**MEMORANDUM**

**FROM:** James Seymour, Acting Development Review Coordinator

**DATE:** December 11, 1995

**SUBJECT:** Temporary Certificate of Occupancy for 76 Shepherd Lane

Site Plan For:

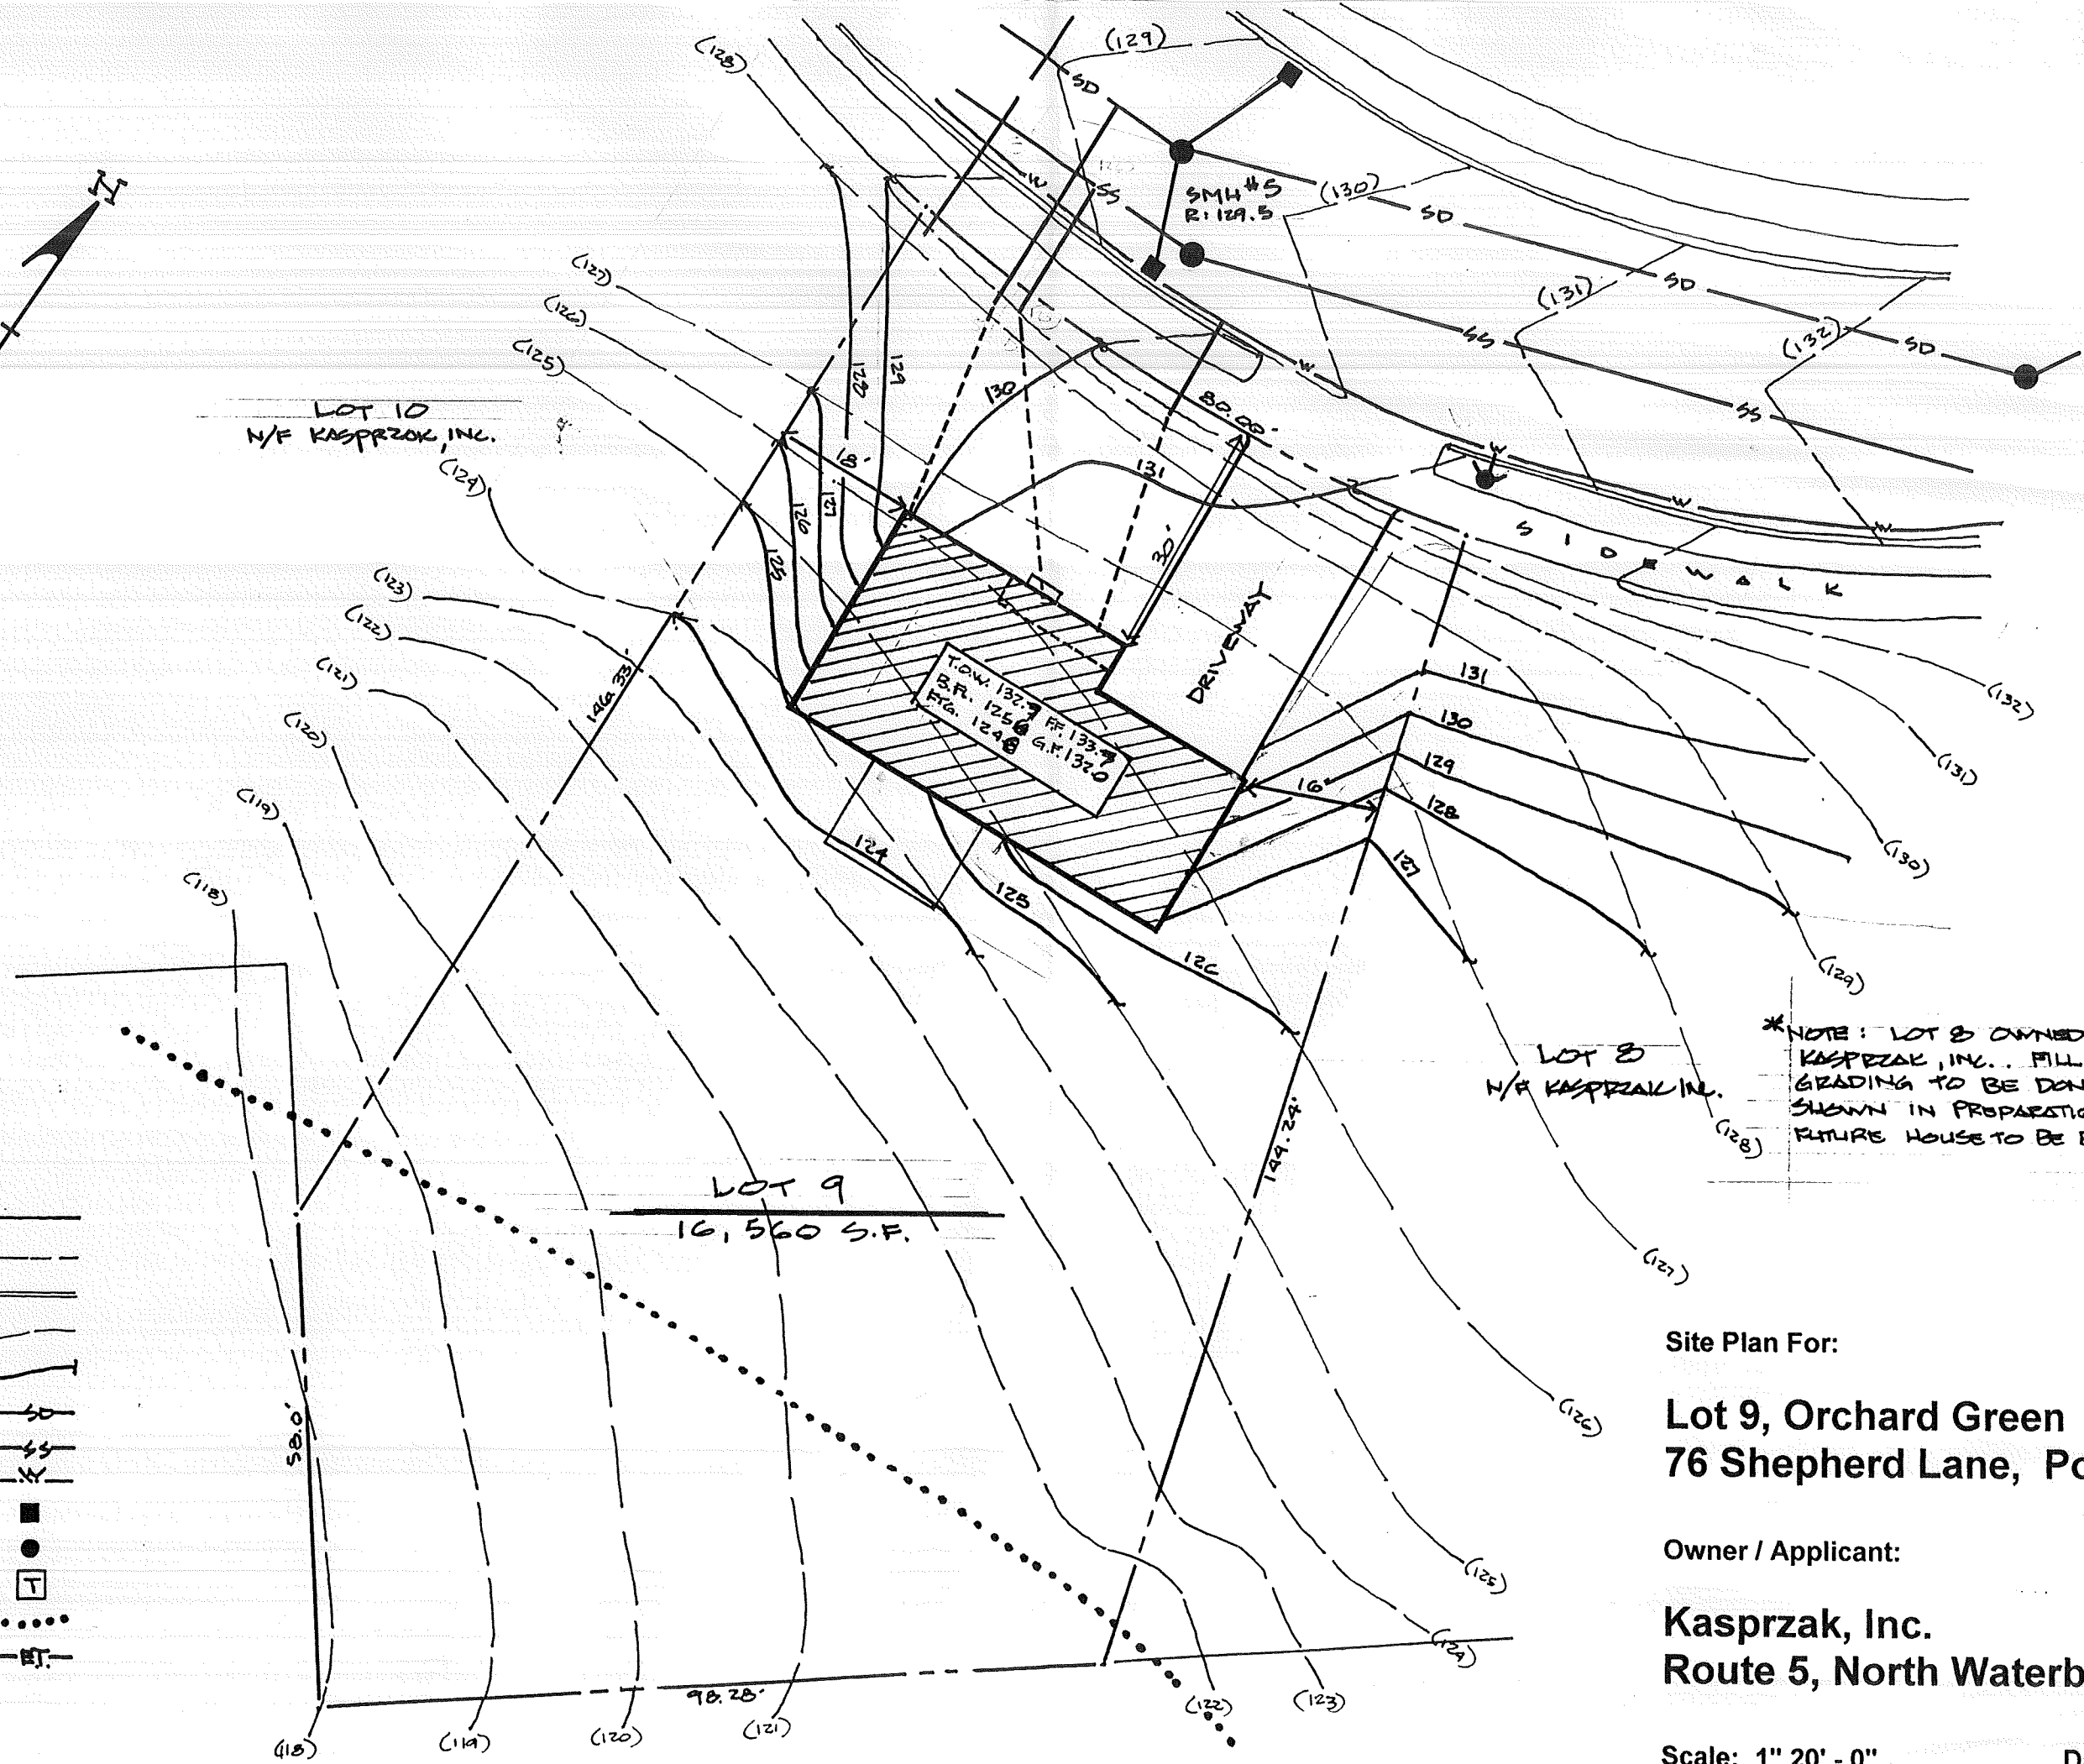
1. At the time of my review, the ground surface was covered with 1-2" of snow making it difficult to review the lot grading. It appears that lot grading may not be necessary in the spring. In the spring once the soil is unfrozen, the disturbed lot area shall be loamed, seeded and mulched no later than May 1, 1996 and approved by the Development Review Coordinator.

3. Siltation fencing shall be installed at the limit of construction and reviewed by the Development Review Coordinator. The siltation fence shall be properly toed and secured by either a date when ground surface becomes unfrozen enough to install fencing or a date no later than April 1, 1995. Siltation fence may be removed once areas disturbed by construction have become 80% revegetated.
